# COMPLETED 04/11/08 SH DRB CASE ACTION LOG (FINAL PLAT)

DRB Application No.: 08DRB-70159	Project # 1006200
Project Name: REPLAT OF TRACTS 1&2, MESA DEL SOL INNOVATION PARK	
Agent: BOHANNAN HUSTON INC.	Phone No.: 823-1000

**April 9, 2008  
DRB Comments**

**RE: Tracts 1 & 2, Mesa del Sol Innovation Park**

PLAT OF  
**TRACTS 1-A, 1-B, 2-A, 2-B, OS-5  
 & OS-6**  
**MESA DEL SOL  
 INNOVATION PARK**  
 (A REPLAT OF TRACTS 1 & 2, MESA DEL SOL  
 INNOVATION PARK)  
 ALBUQUERQUE, BERNALILLO COUNTY, NEW MEXICO  
 FEBRUARY, 2008

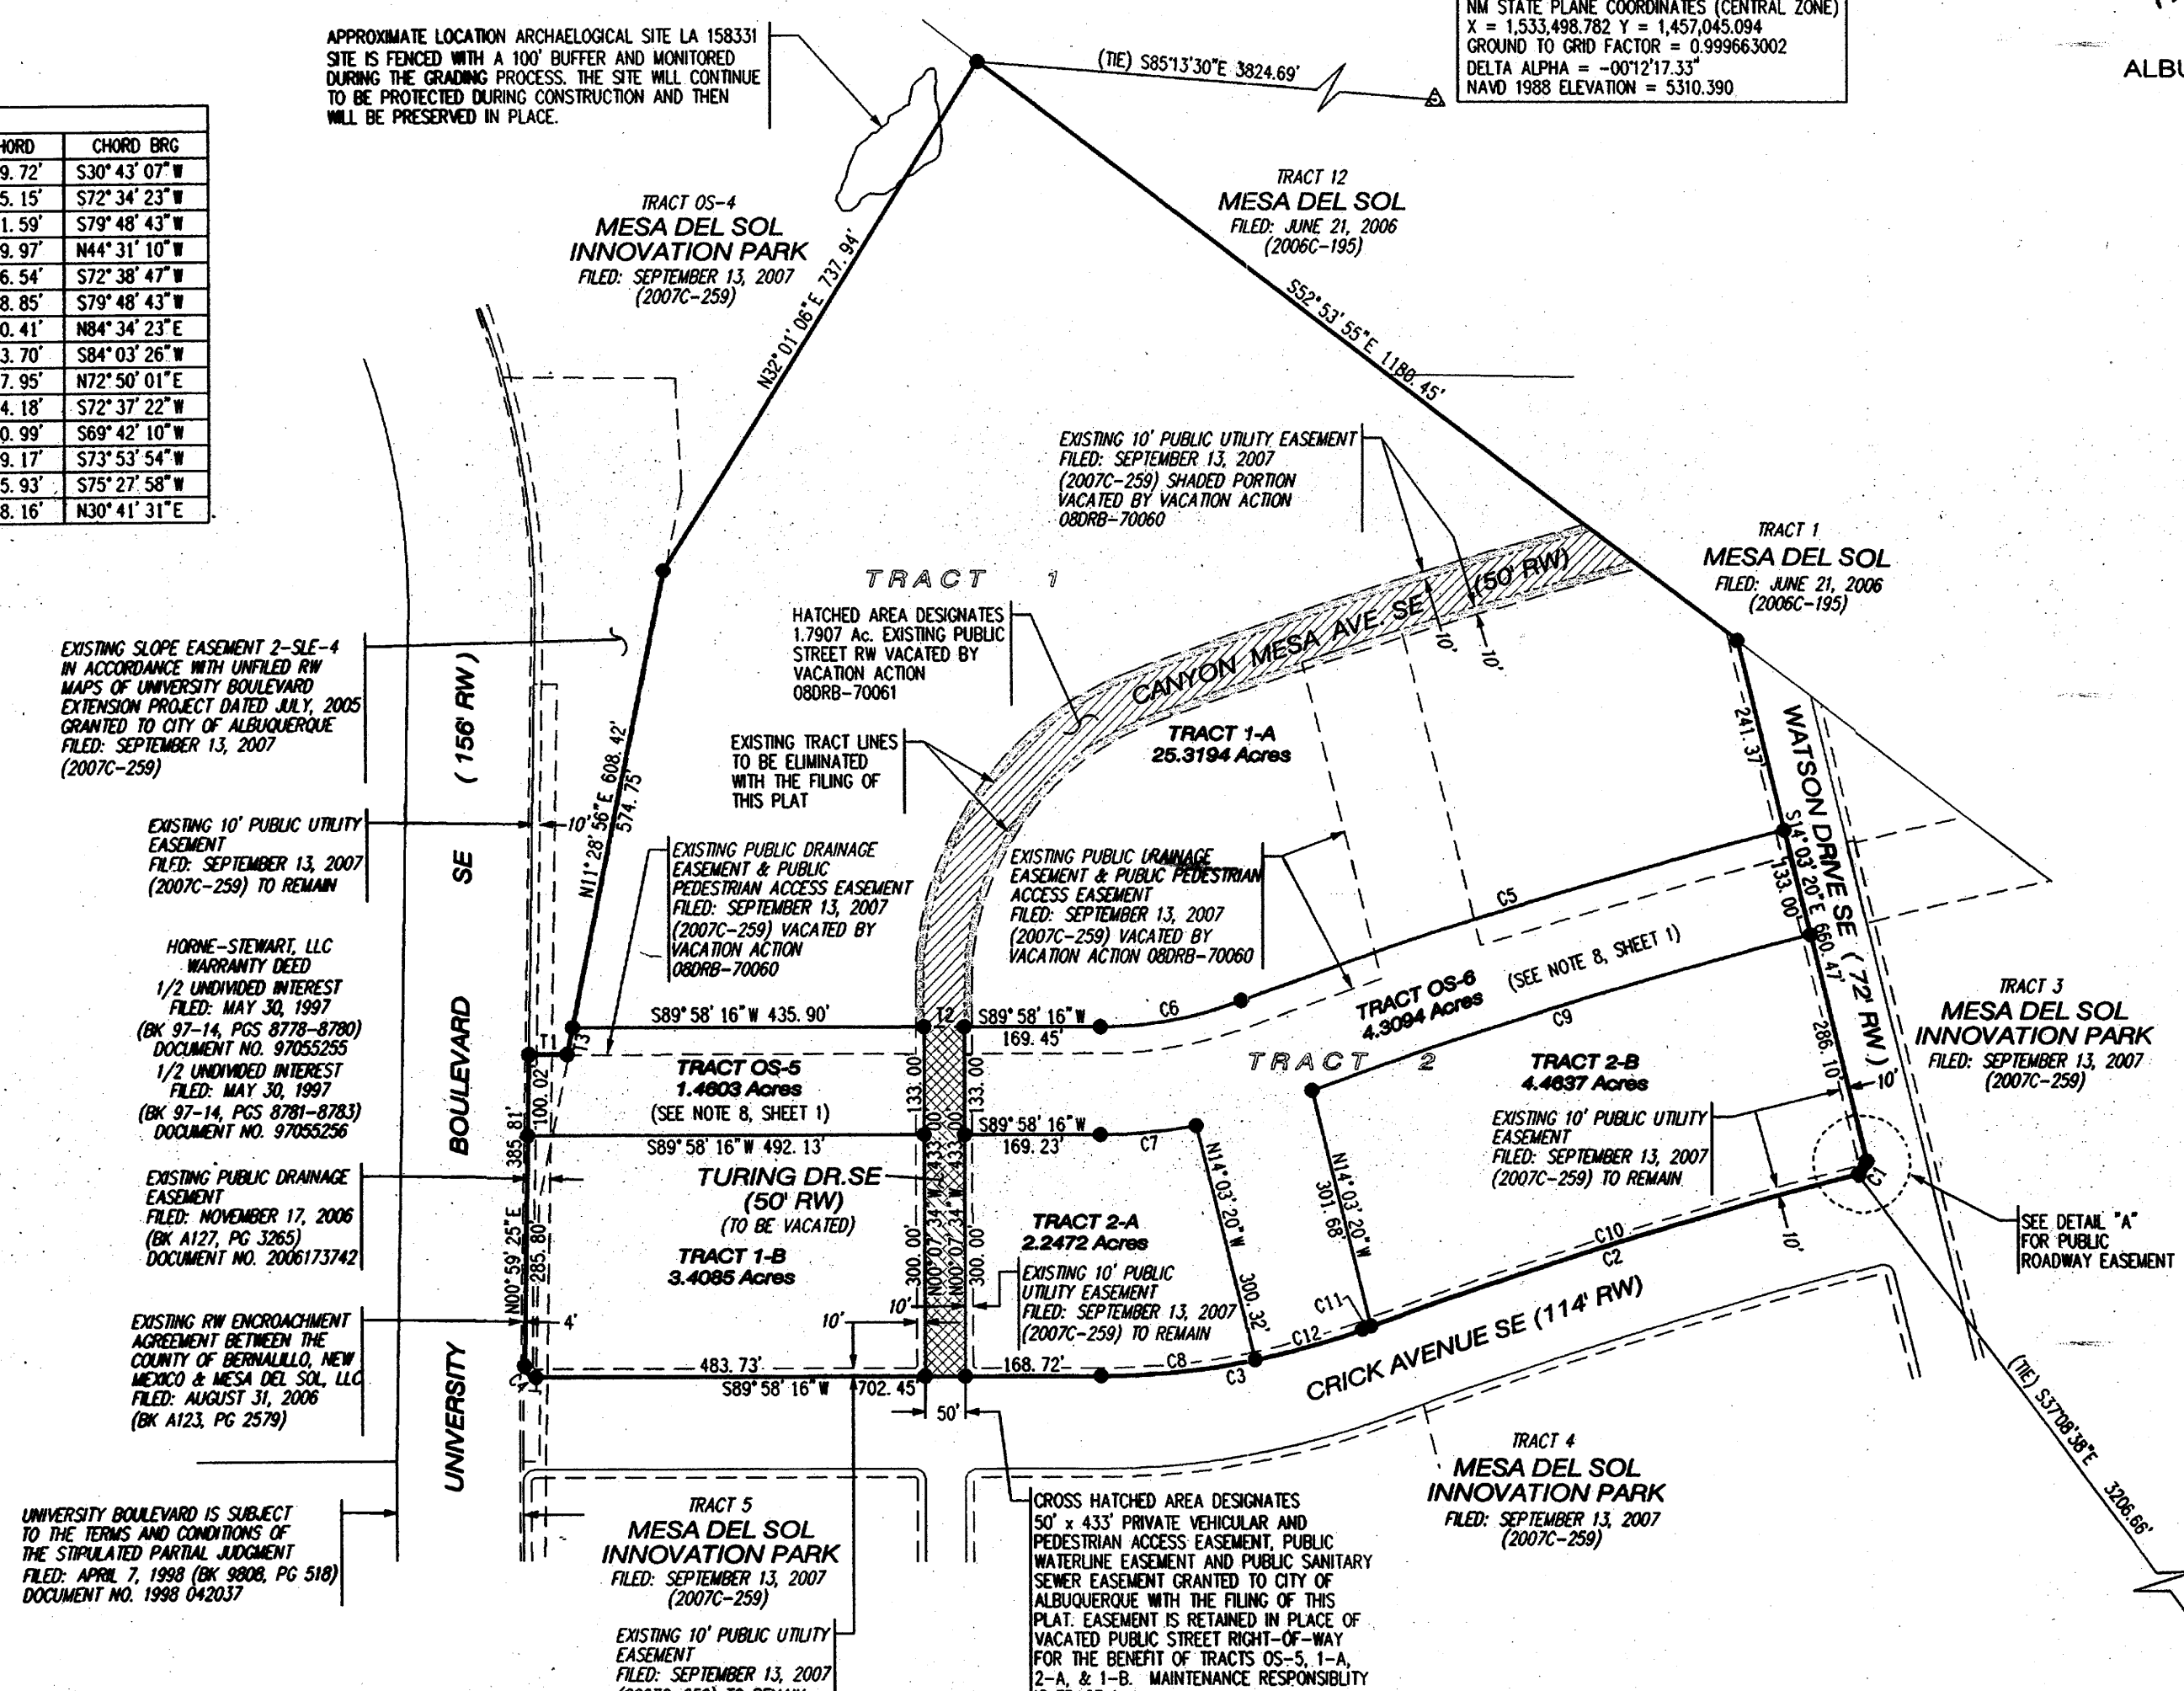
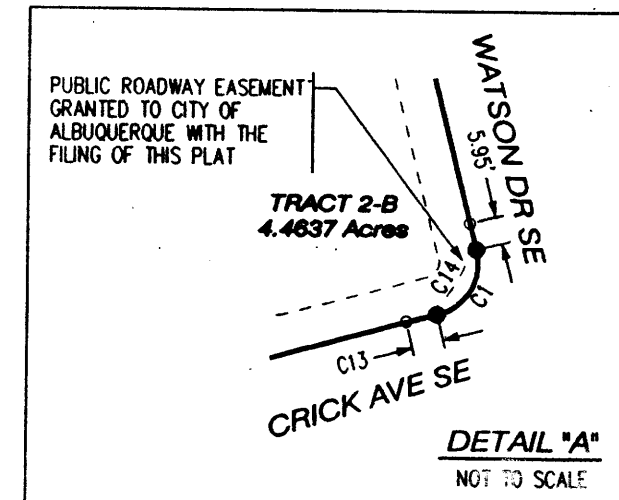
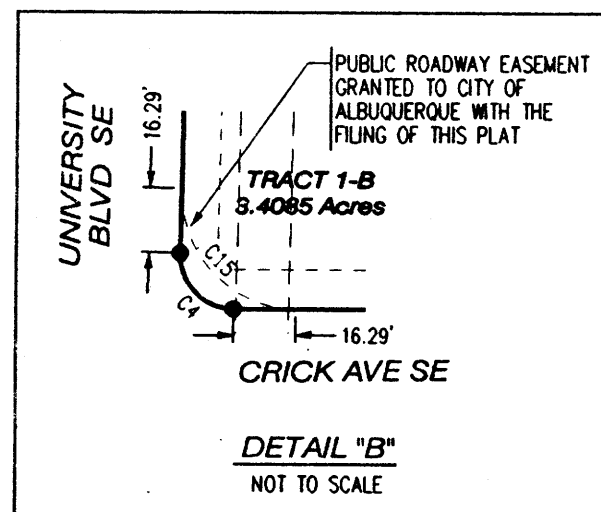
TRANSPORTATION: 30' radius at University and Chik SE.

Maintenance of proposed Tracts OS-5 and OS-6 must be addressed per the Subdivision Ordinance prior to final sign-off.

For future reference, please do not identify the property's zoning (Note 3) on the plat.
